National Infrastructure Planning
Temple Quay House
2 The Square
Bristol
BS1 6PN

Our ref: AC/2022/131328/01-L01
Your ref: EN010106
Date: 11 November 2022

**APPLICATION FOR DEVELOPMENT CONSENT ORDER - SUNNICA ENERGY FARM –
EXA'S WRITTEN QUESTIONS (EXQ1)**

Drawing Title
**FIGURE 3-19A
CONSTRUCTION COMPOUNDS &
ACCESS SUNNICA EAST
SITES A AND B**

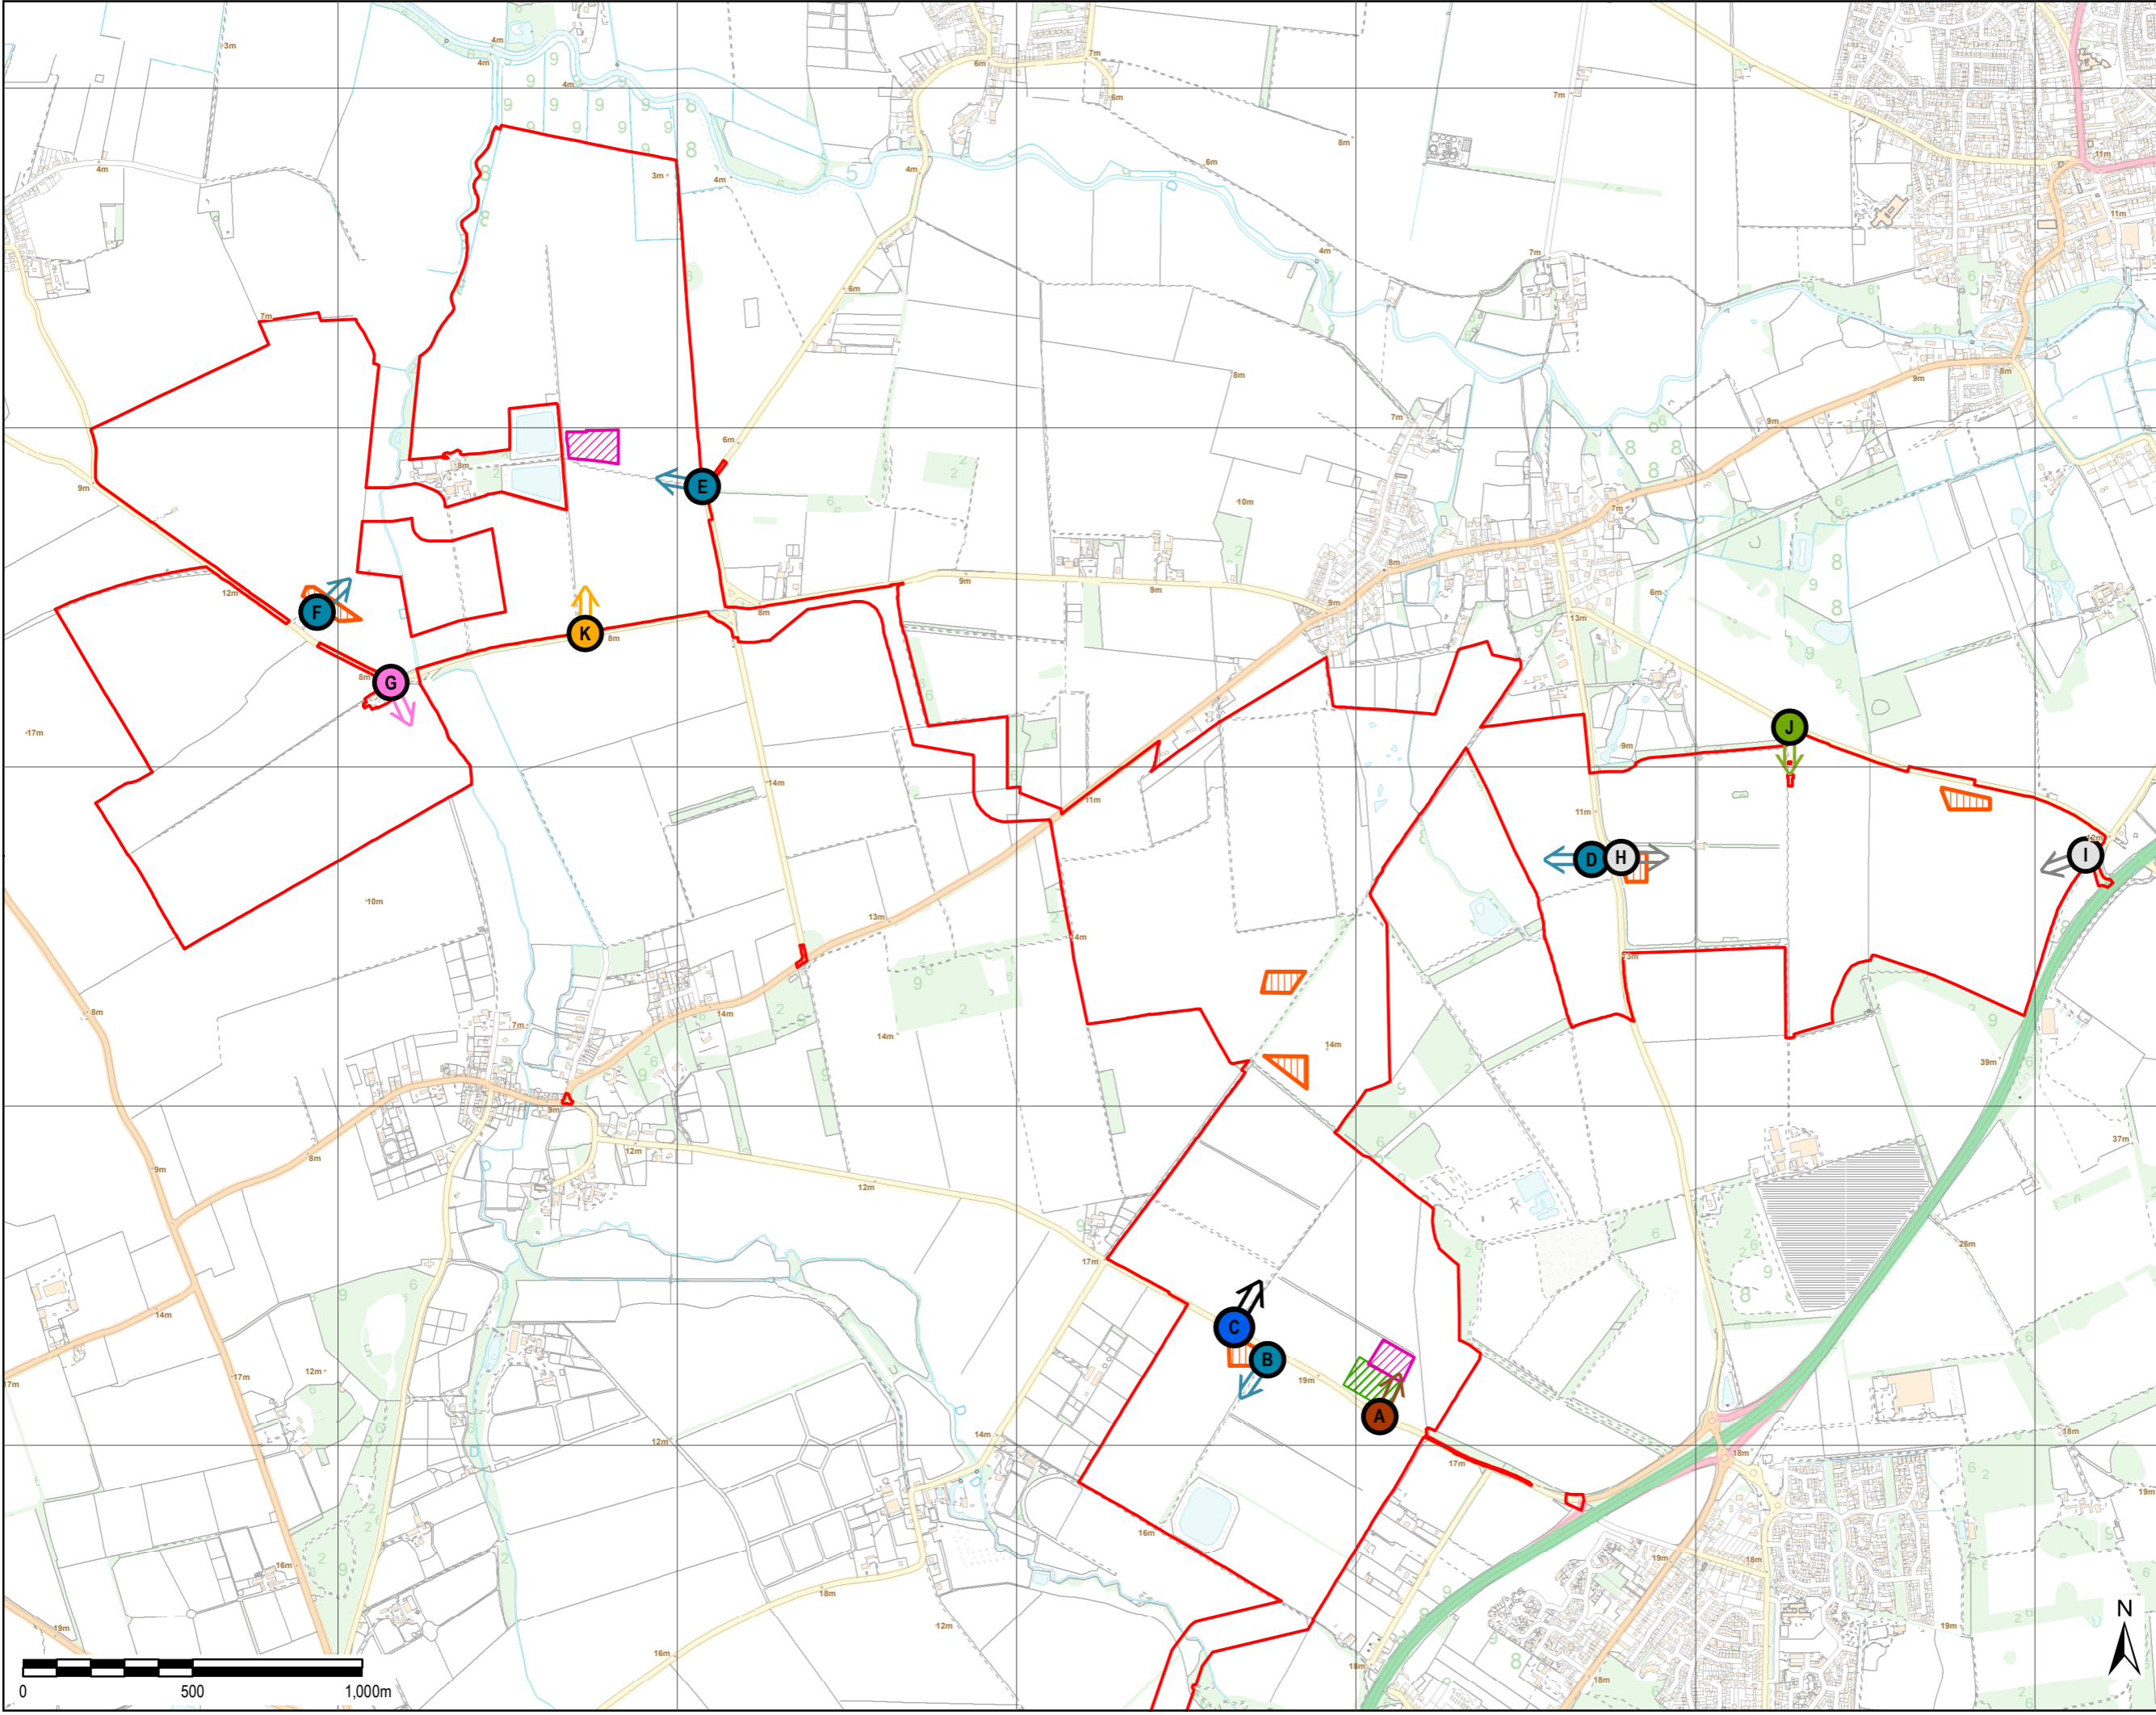
ExQ1	Question to:	Question:
		<p>submitted by the Applicant [AS-007 to AS-012] in response to s51 advice, and if not please explain what matters, in your view, remain to be addressed and why?</p> <p>EA response:</p> <p>The five issues with the submitted Flood Risk Assessment (FRA) referenced in our Relevant Representations have not been addressed by the revised FRA submitted by the Applicant [AS-007 to AS-012).</p> <p>We are having ongoing discussions with the Applicant and have been consulted on a draft FRA Technical Note (dated September 2022), submitted to us on 30 September 2022, which has been prepared to address the issues we have raised. We understand that an FRA Addendum will be submitted by the Applicant to address the issues we have raised.</p> <p>Based on our review of the draft FRA Technical Note, we consider that the following matters still remain to be addressed:</p> <p>Issue 1.1 – The applicant has undertaken breach modelling of Burwell Lode to address this issue but as there are some uncertainties with the model that has been used, sensitivity testing of this model needs to be undertaken before we can consider whether the outputs of this and the proposed mitigation measures are acceptable. As such, this issue remains to be addressed.</p> <p>Issue 1.2 – The FRA Technical Note demonstrates that all the solar stations will be located outside of the floodplain; we are therefore satisfied that no floodplain compensation is required. This issue should be addressed in the forthcoming FRA Addendum.</p> <p>Issue 1.3 – Although relevant modelled flood levels have been included in the FRA Technical Note, further assessment of the impact of climate change on flood risk still needs to be undertaken based on the credible maximum scenario. It still needs to be demonstrated that the solar panels within Flood Zone 3 will be raised high enough to ensure these will remain operational for the lifetime of the development, taking into account the likely effects of climate change. As such, this issue remains to be addressed.</p> <p>Issue 1.4 – Drawings have been included in the FRA Technical Note that show the proposed site layout in relation to the extent of Flood Zones 3b, 3a and 2. We understand that these drawings will also be included in the FRA Addendum. As such, this issue should be addressed in the forthcoming FRA Addendum.</p> <p>Issue 1.5 – No drawings have been included in the FRA Technical Note showing the proposed location of</p>

ExQ1	Question to:	Question:
		temporary site compounds and storage areas in relation to the flood zone extents. We understand that these drawings will be included in the FRA Addendum.
Q1.11.16	EA	<p>In assessing the groundwater resource including abstractors has the Applicant taken adequate account of your records of unlicensed groundwater abstractions for agriculture and domestic uses previously present in the area, referred to in ES Chapter 9 [APP-041] Table 9-4 Main Matters Raised within the Scoping Opinion and statutory consultation, and if not why not?</p> <p>EA response:</p> <p>We are satisfied that the assessments presented in Chapter 9 consider the potential for impacts to licensed and unlicensed (private) groundwater abstractions.</p> <p>Certain water supplies do not require a licence and therefore may not be known to the Environment Agency. Local authorities act as the regulators for private water supplies. The applicant indicated in their submissions (in Chapter 9, paragraph 9.4.5) that they have obtained a search of licensed and unlicensed (private) water abstractions within the vicinity of the Order limits and this information is incorporated into their assessments.</p>
